MECKLENBURG COUNTY
Park and Recreation Department

MEMORANDUM

DATE: August 31, 2020

RE: Rezoning Petition #2020-074 – Redwood Harris Houston

SHEET TITLE:
CONDITIONAL REZONING: CONCEPTUAL SITE PLAN
SHEET NUMBER:
RZ1.0

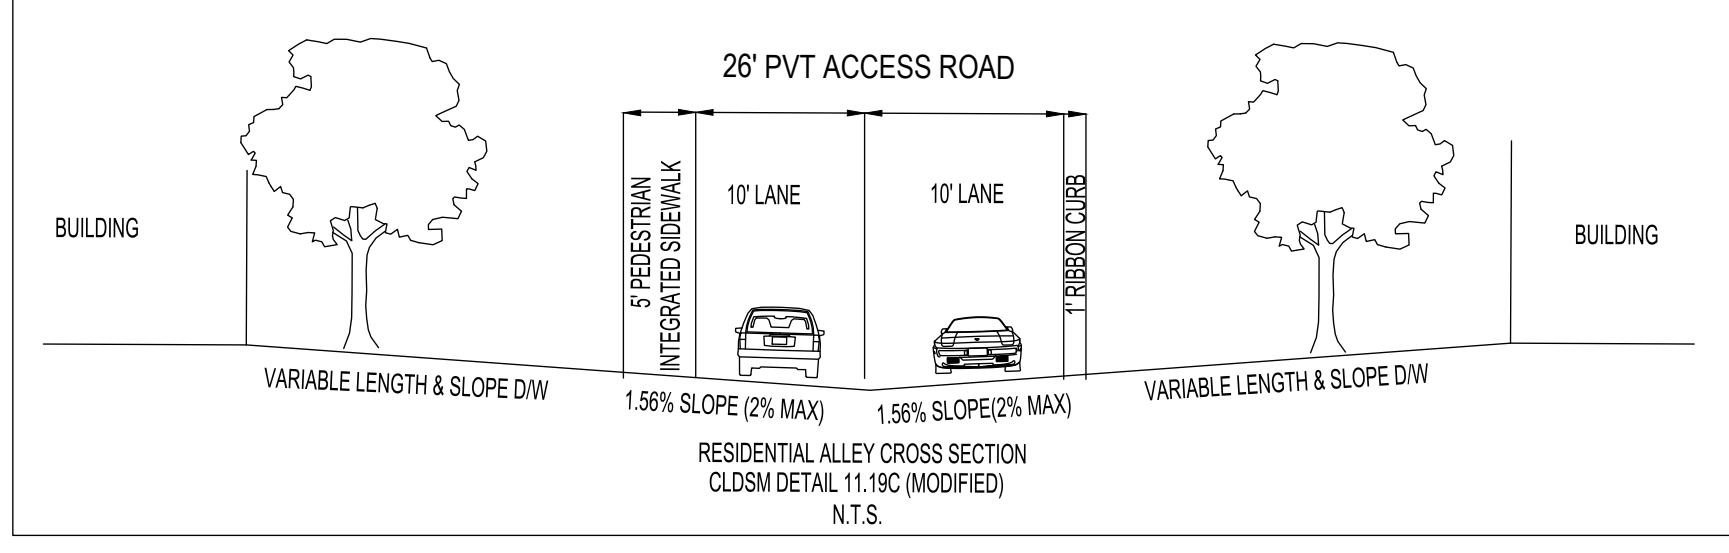
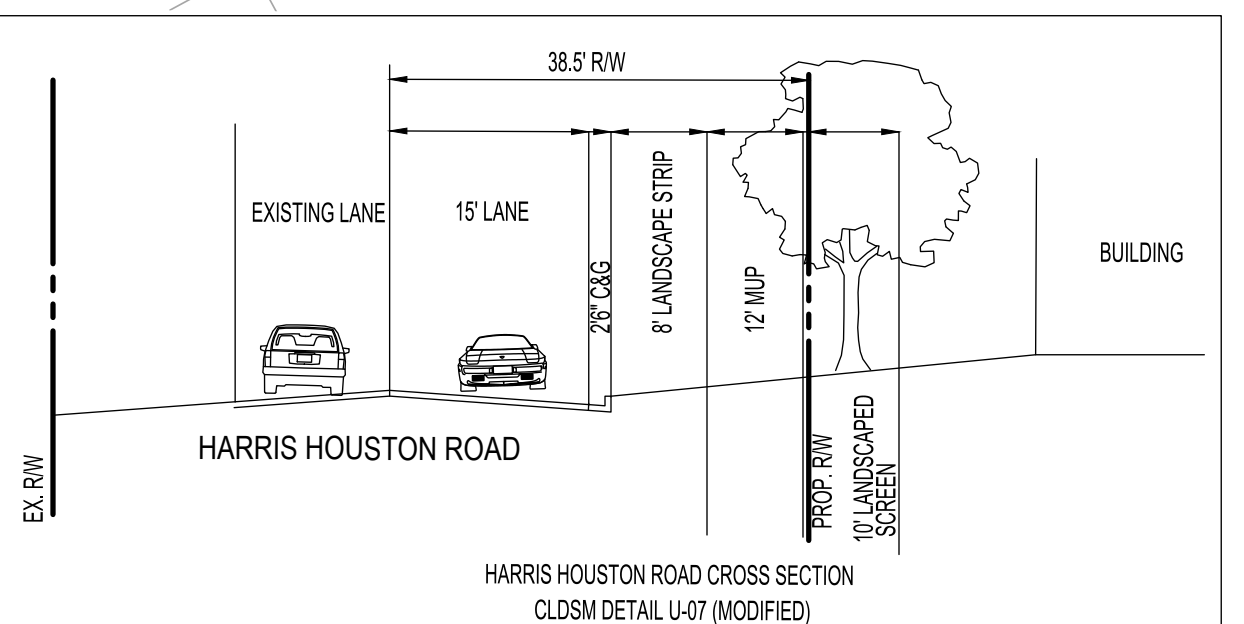
MCPR accepts the dedication and conveyance of a greenway easement to Mecklenburg County - the 50' PCCO Buffer of Mallard Creek Trib. as noted minus any BMP infrastructure as shown on the 8.18.20 revised site plan. Please remove the reference to "park and recreation" on the note. The dedication is to be to Mecklenburg County.
